Ribble Valley Borough Council Development Control Council Offices Church Walk Clitheroe Lancashire BB7 2RA Our ref:NO/2018/110761/04-L01Your ref:3/2018/0361

#### FULL APPLICATION FOR THE DEMOLITION OF EXISTING STRUCTURES AND REMOVAL OF CULVERT TO SABDEN BROOK; DEVELOPMENT OF 30 DWELLINGS INCLUDING RE-CONSTRUCTION OF FORMER MARBIL OFFICE BUILDINGS AS NEW DWELLINGS; RECONSTRUCTION OF BASE OF MILL CHIMNEY AS AN ECOLOGY TOWER AND ASSOCIATED ACCESS AND LANDSCAPING

#### VICTORIA MILL, WATT STREET, SABDEN

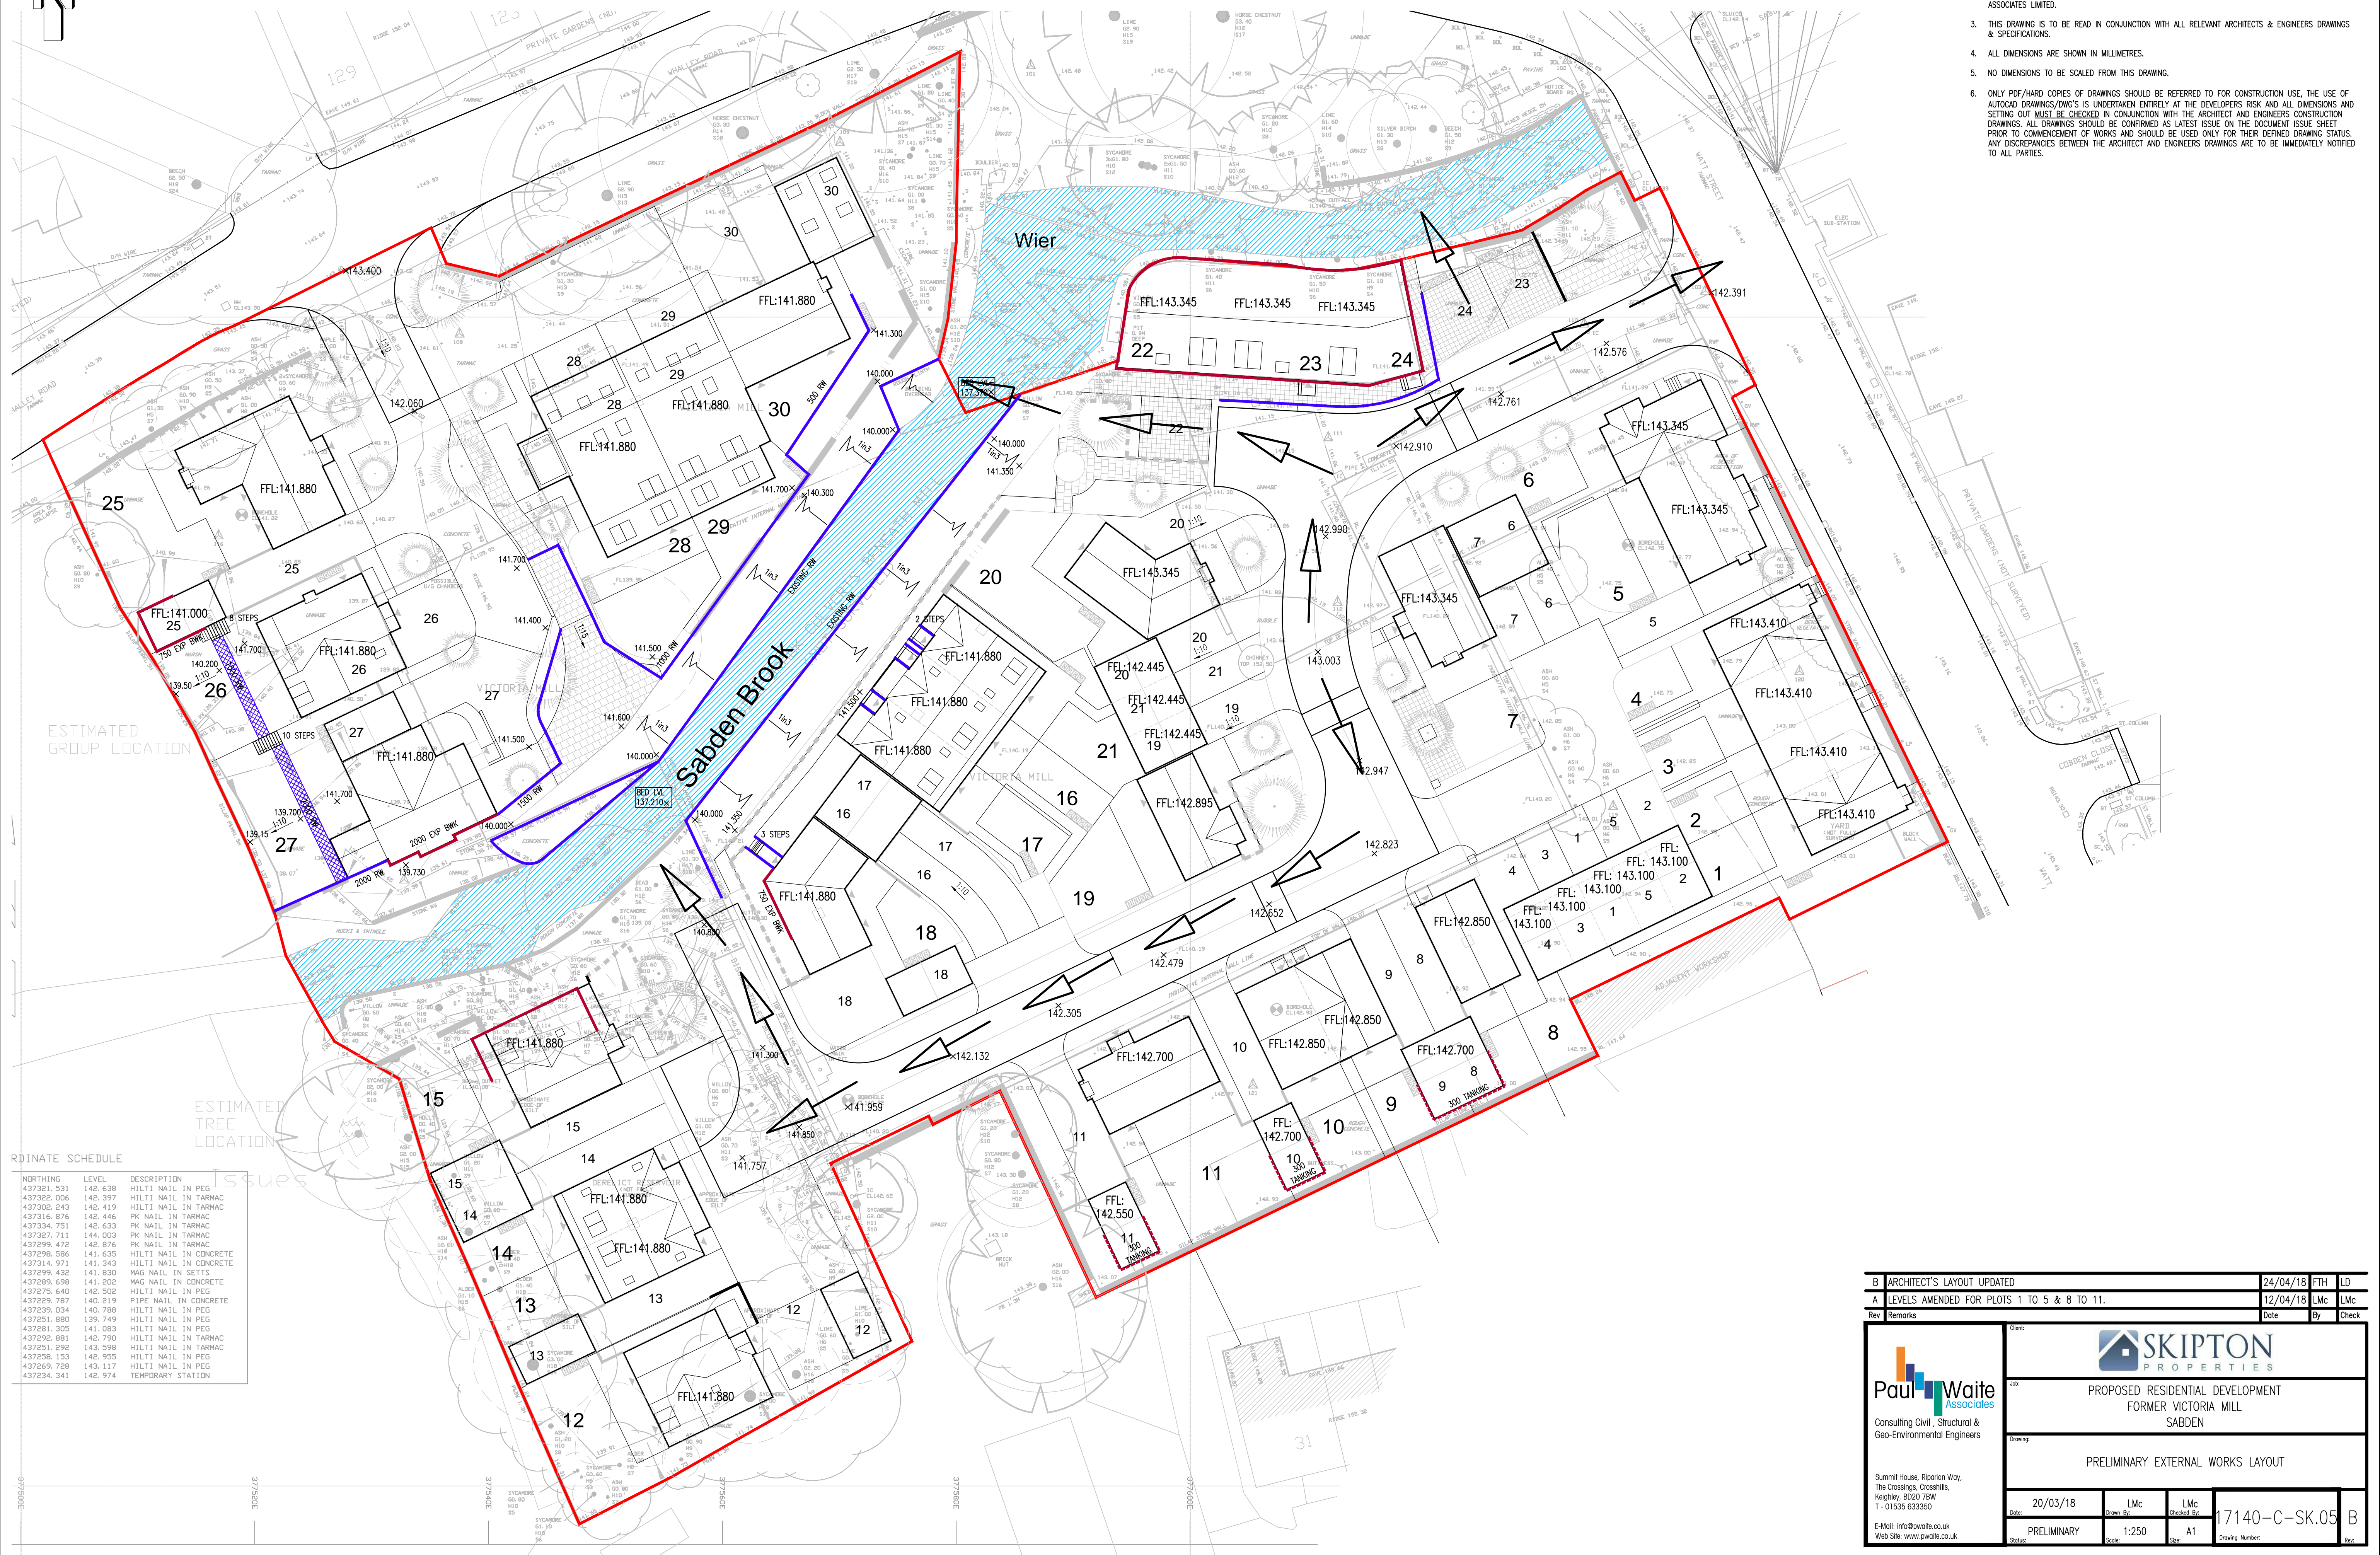
The revised plans demonstrate that the dwellings on plots 15 and 27 have been moved. They are no closer to Sabden Brook than any dwellings proposed through application 3/2014/0188. The cross-section through plots 15 and 27 also demonstrates that there will be no infilling of the channel as a result of the proposed development. The provision of a 300mm high raised highway bump at the site entrance has also been highlighted on the plans to reduce the risk of flooding from off-site.

The daylighting of the Sabden Brook culvert forms part of the proposed development, but it is not identified as a flood risk mitigation measure in the FRA. To ensure that the works to the culvert are completed, we recommend that any subsequent approval is conditioned as follows:-

**Condition** No occupation of the dwellings hereby approved shall take place until the Sabden Brook culvert has been removed and the watercourse restored to open channel in accordance with drawing 1582SPL/VMS-SL01 Rev K and drawing 17140-C-SK.05E
